Submission to MP08_0098 MOD 13 - Construction of a new hotel and residential tower and alterations to existing building

We write on behalf of the property owners at numbers 851 and 852 (client) of the Star Apartments at 80 Pirrama Road, Pyrmont, also known as the Astra Residence.

Drawing
PROPOSED SITE PLAN - LEVEL 06

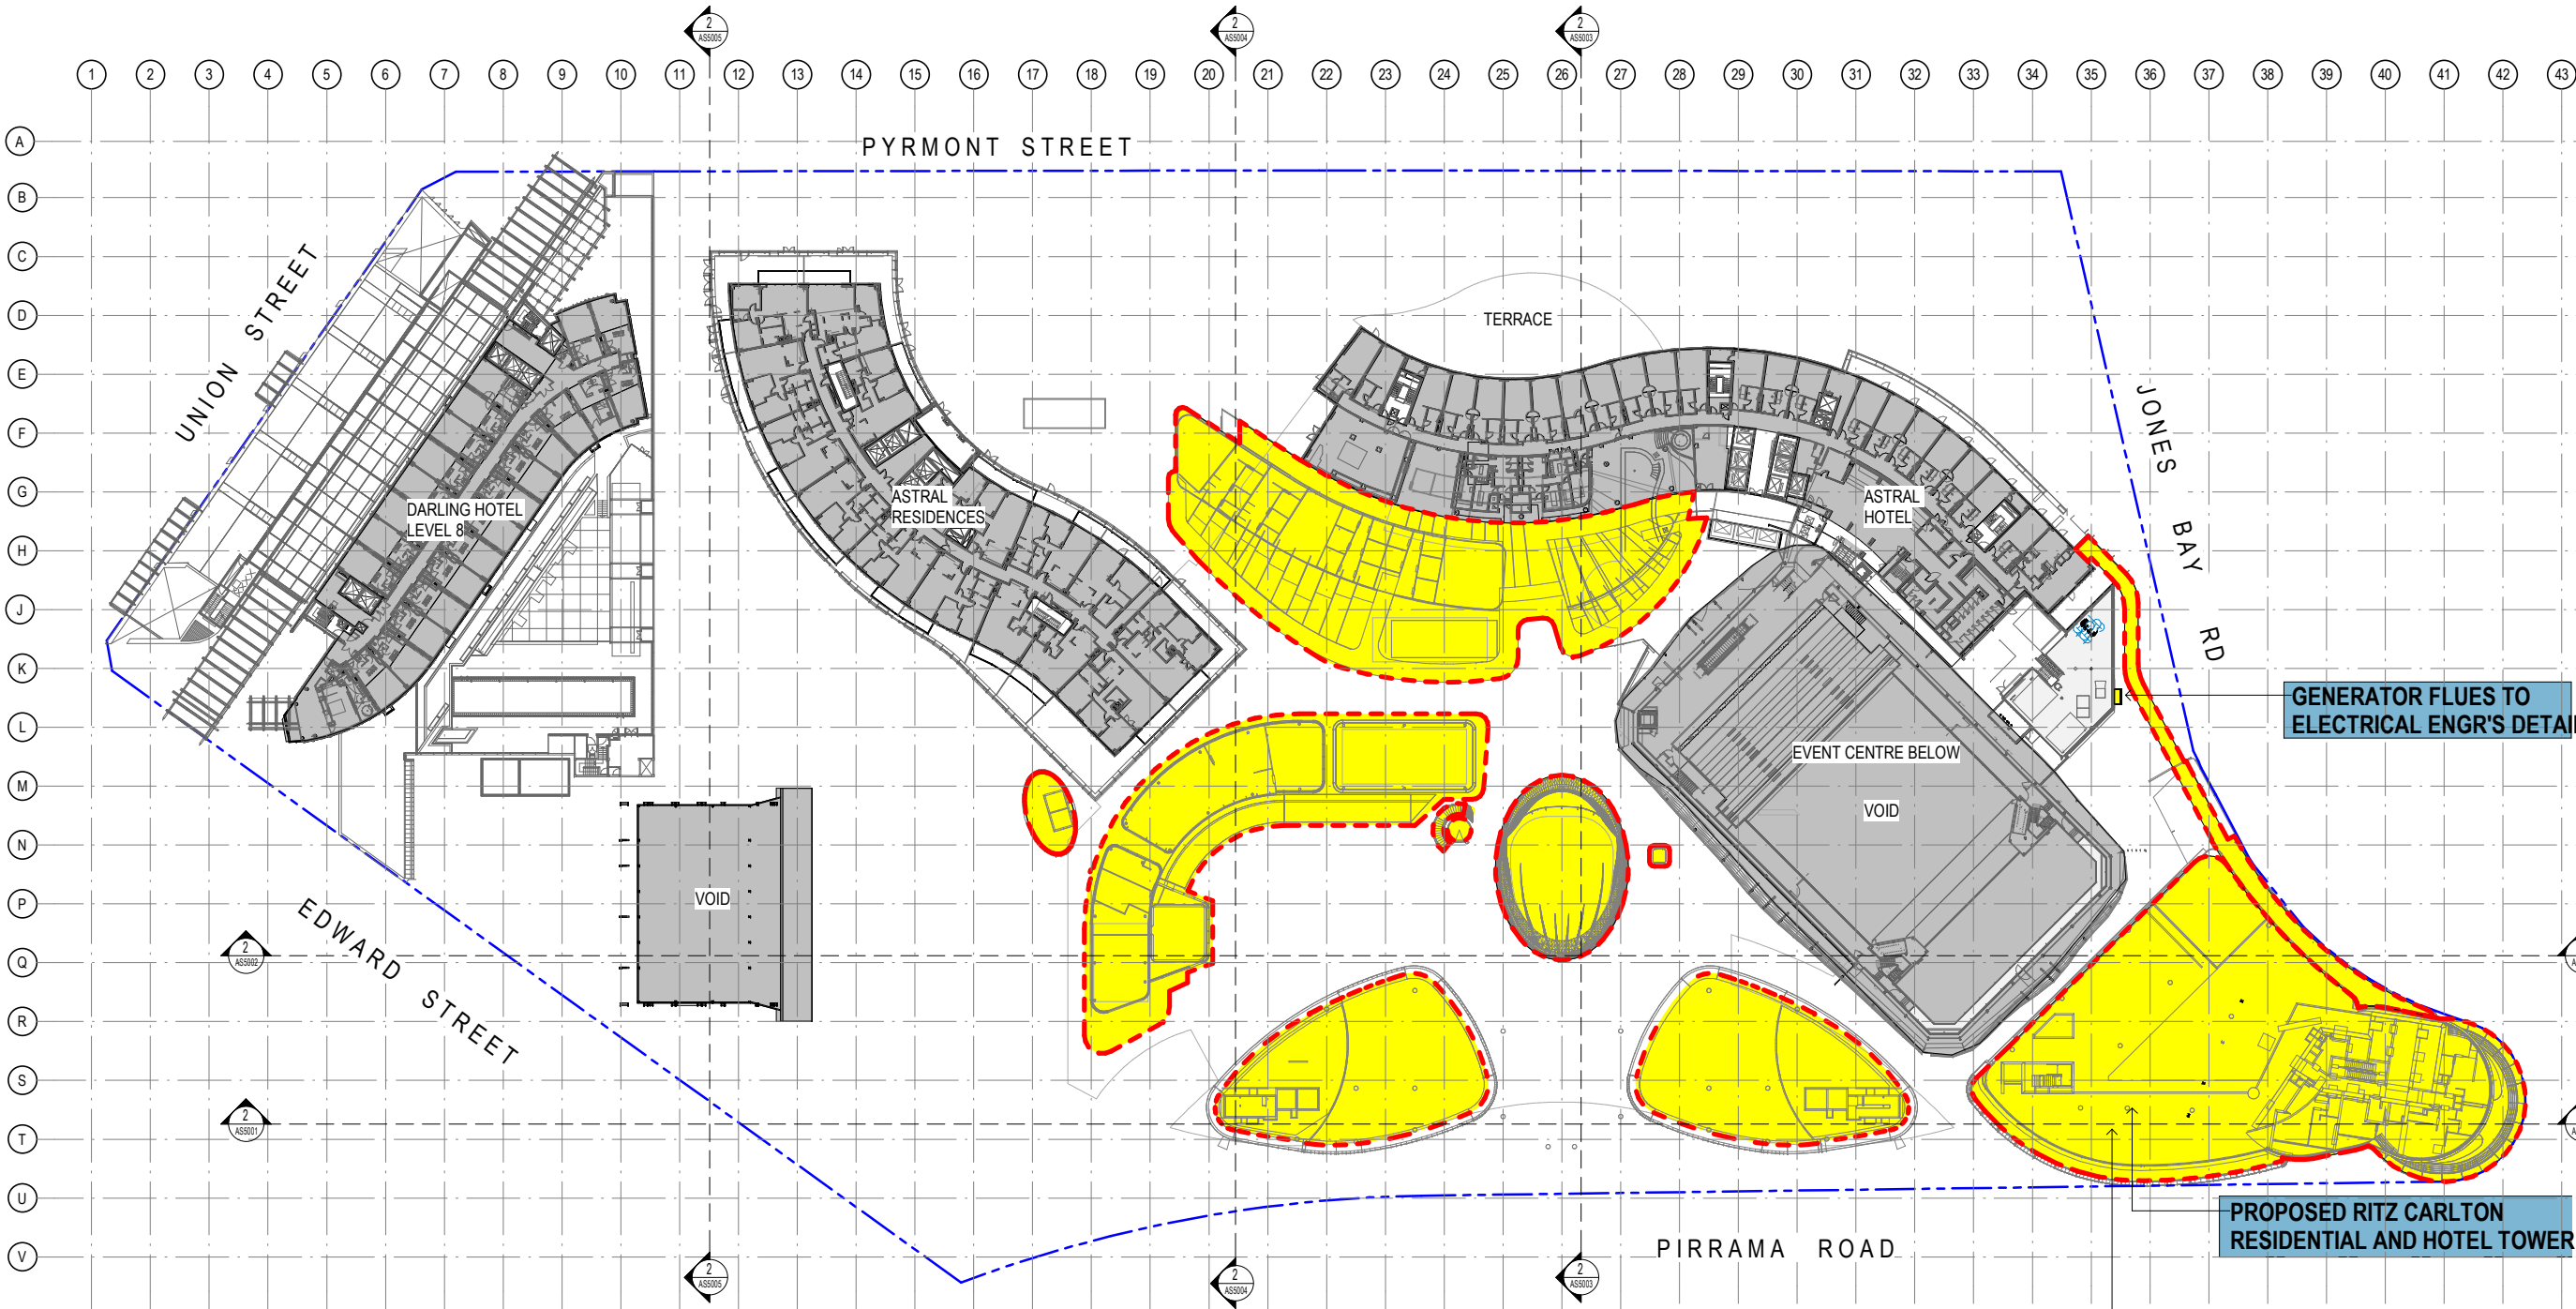
- » Modification 13 will intensify the noise impacts on the residents of the Astral building through the activation of uses on Level 5, including 'flexible events/designated event spaces'

- » Patrons of the proposed uses at the Level 5 space will have line of sight with the facades of the Astral Residences (primarily the northern façade) impacting residents' privacy
- » Mitigation measures are considered unlikely to be able to adequately balance the use of patrons while protecting the privacy and enjoyment of use for occupants of the Astral Residence

PROPOSED SITE PLAN - LEVEL 07

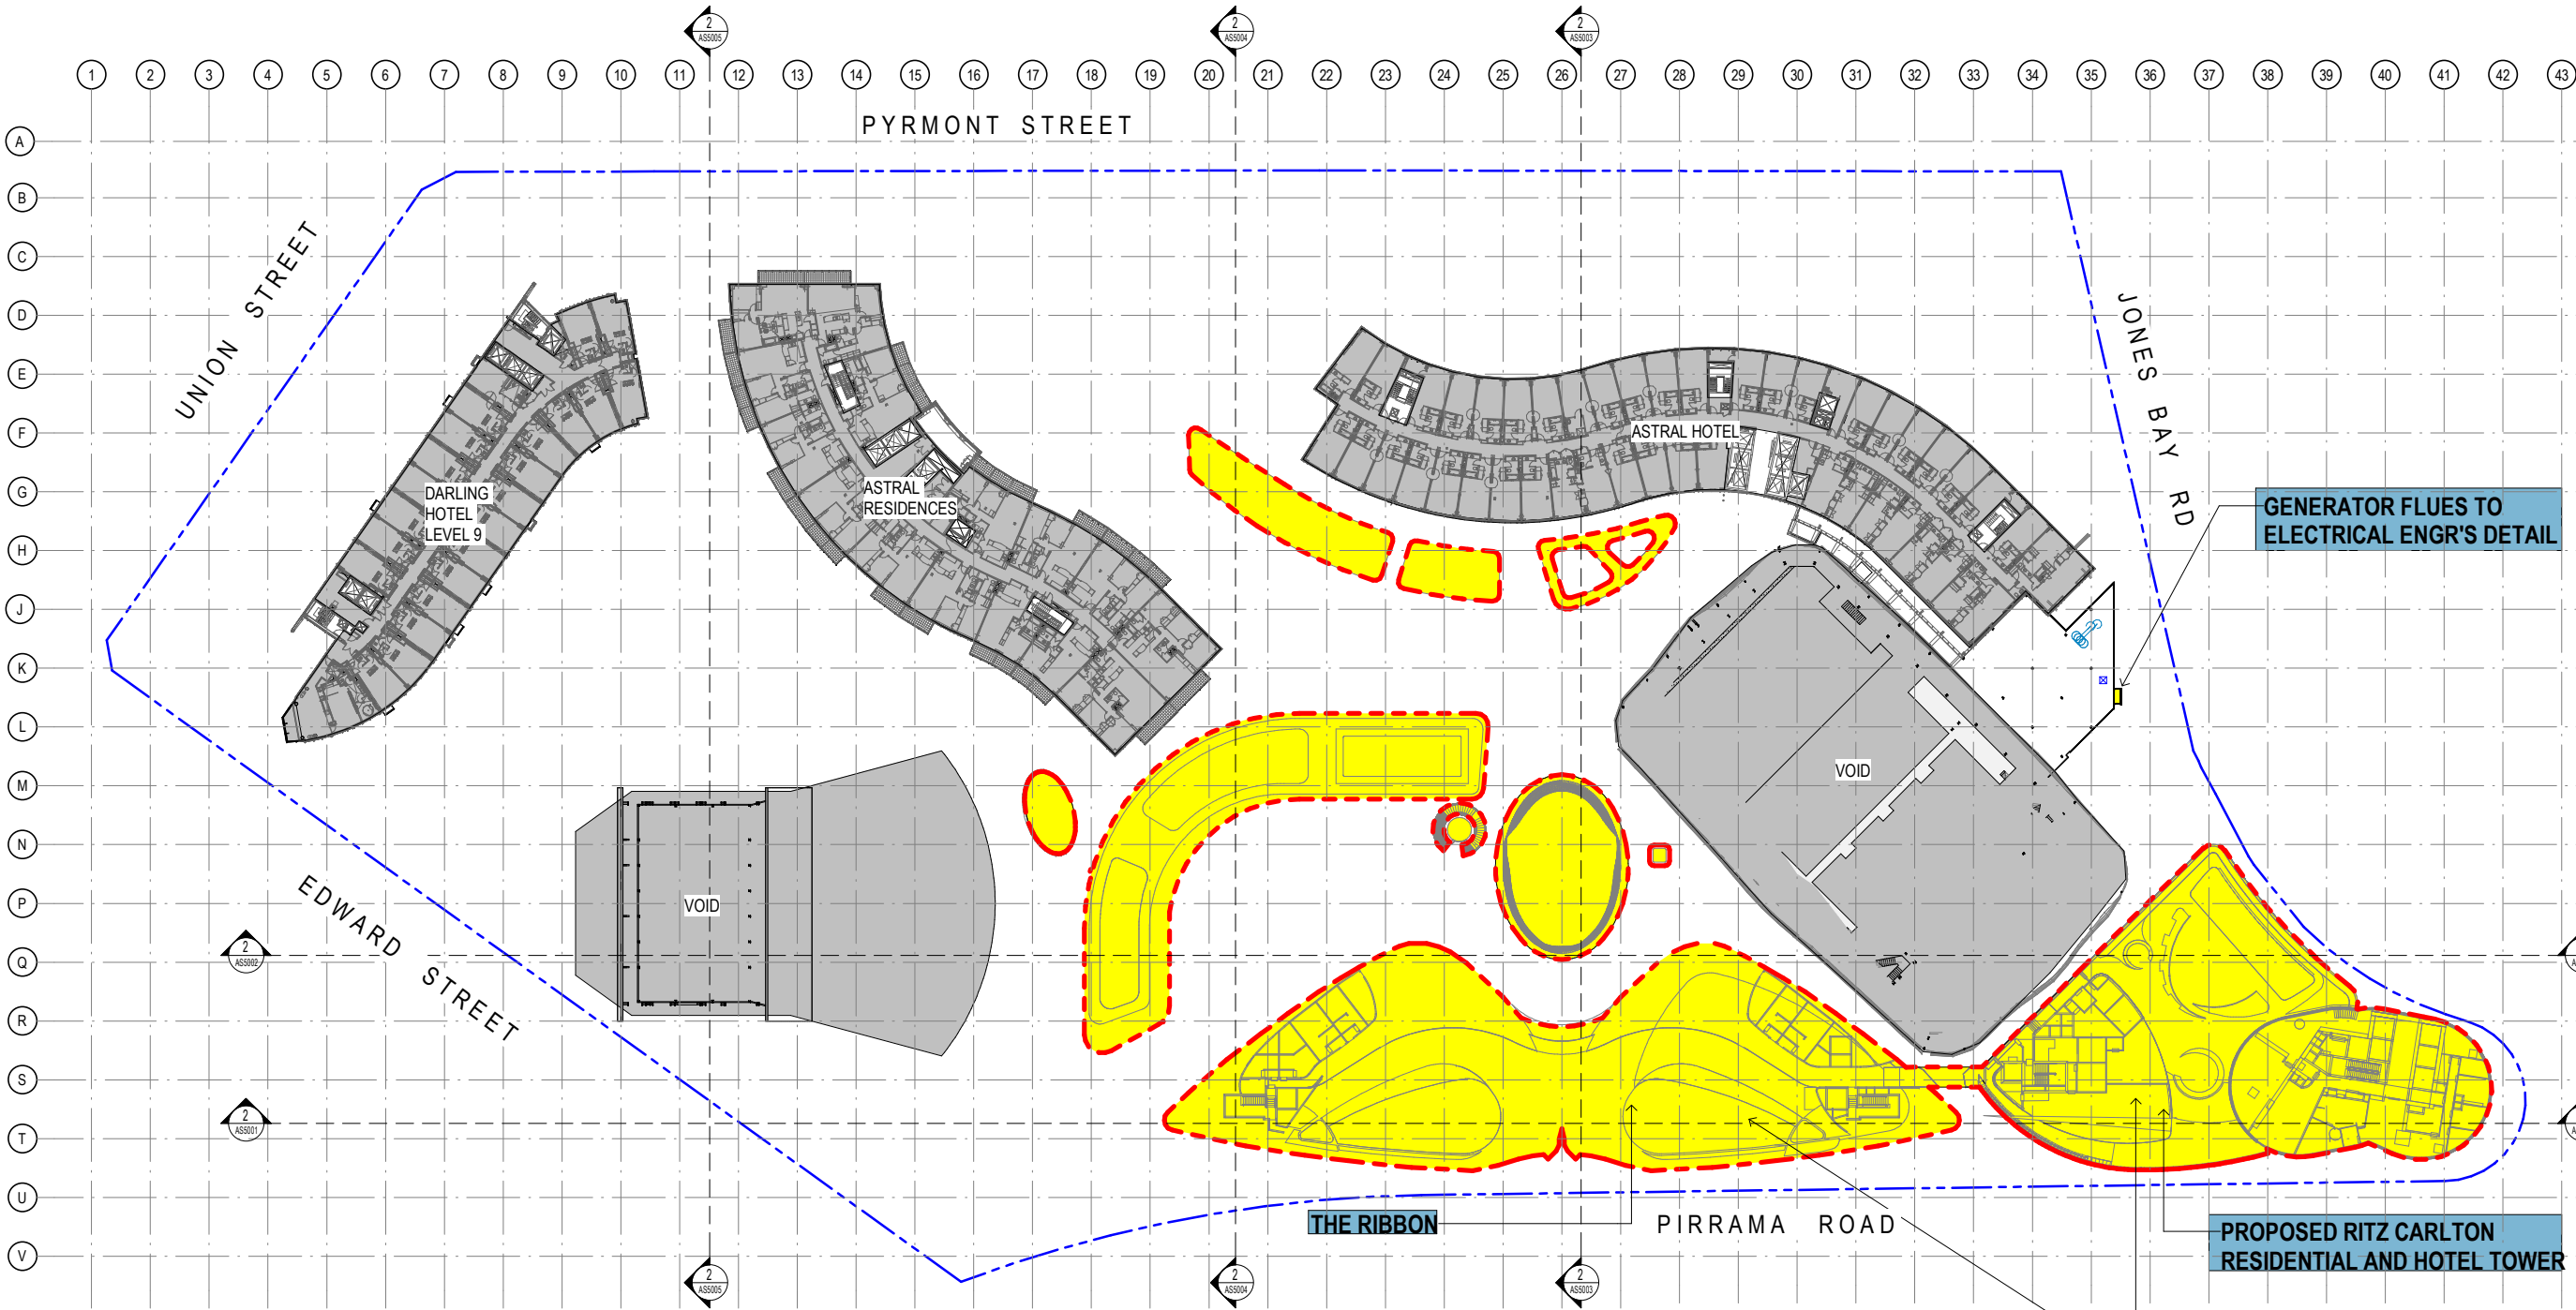
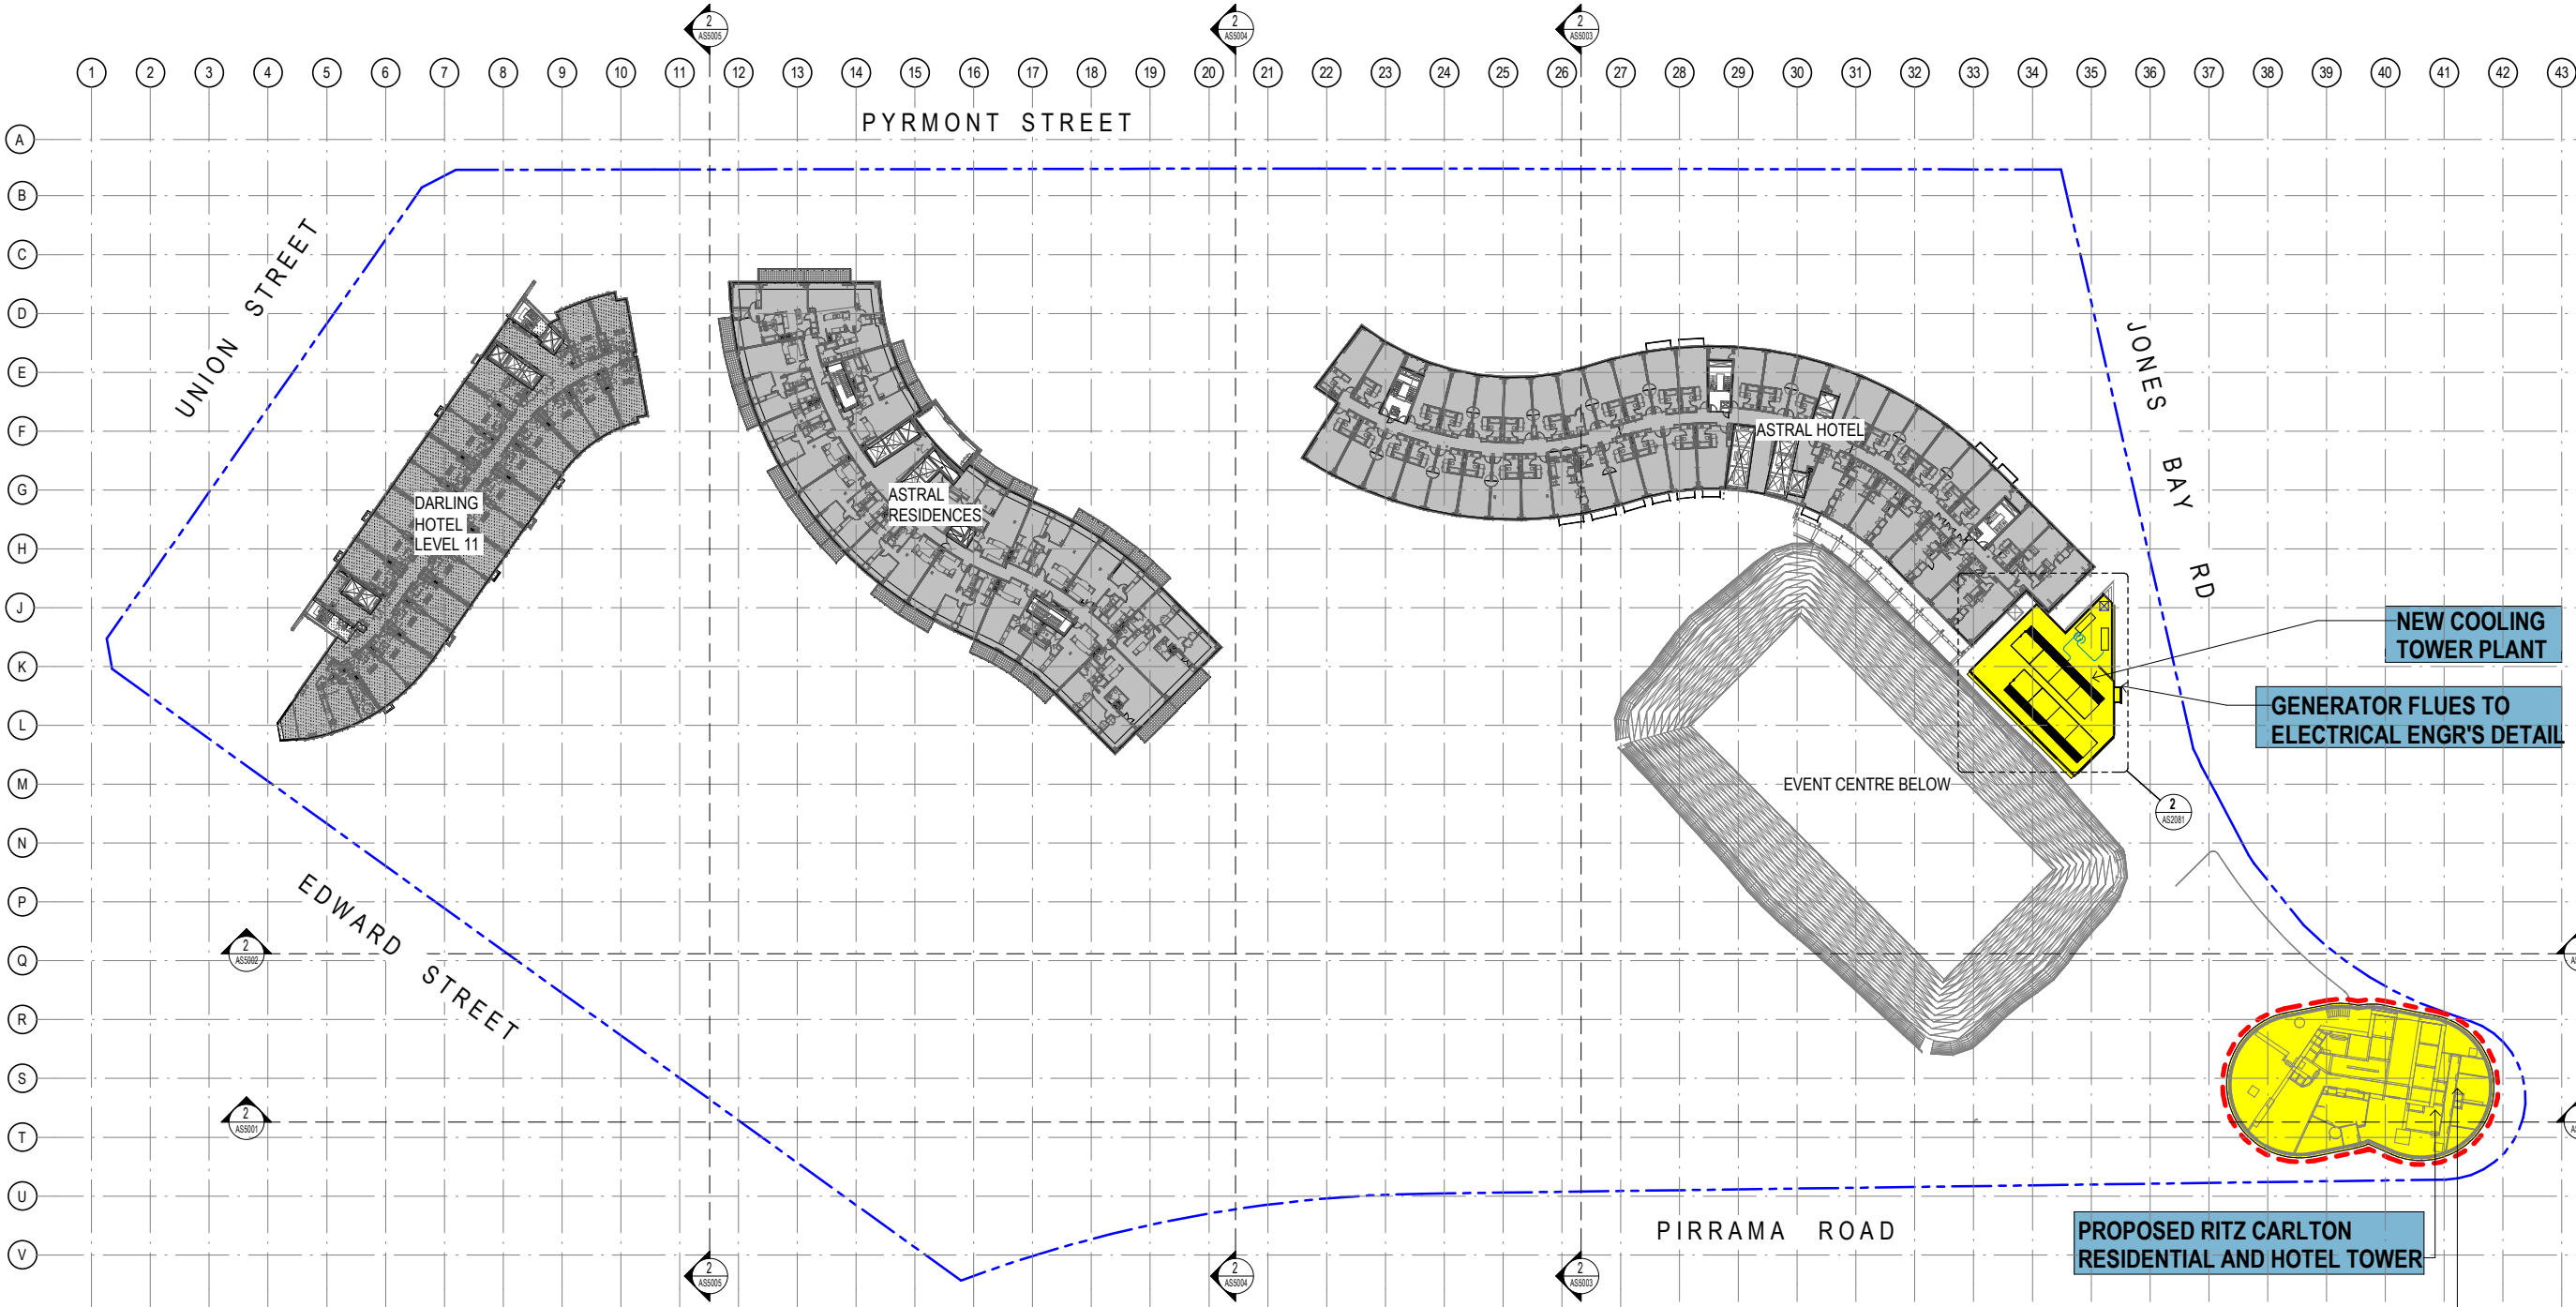
- » The current views enjoyed by residents and occupants of the Astral Residences are highly valued. The proposed ribbons are noted as architectural features connecting new uses to each other. However, it appears that these architectural features will cause detrimental by causing a disruption of these views

- » It is clear that the impact of the ribbon buildings, and to some extent the Level 5 Sky Terrace, will result in the impeding of primary, existing water views for our clients' units (and those units below). These views were assessed to be 'high importance' and 'moderate to high visual impact' in the VIA

- » The 28m LEP restricted height limit appears to impede partial views to the harbour here with protruding elements such as the ribbon building further cancelling out, '...water and horizon interface...' in its entirety

- » The development and consideration of alternative design solutions for the Ribbon building's roof line to allow for existing resident view corridors to remain in place
- » Ensuring all amenity impacts associated with the proposal have been considered including appropriate conditions in any future consent to safeguard our client's residential amenity
- » Placing a restriction on the hours of operation for Level 5 uses.
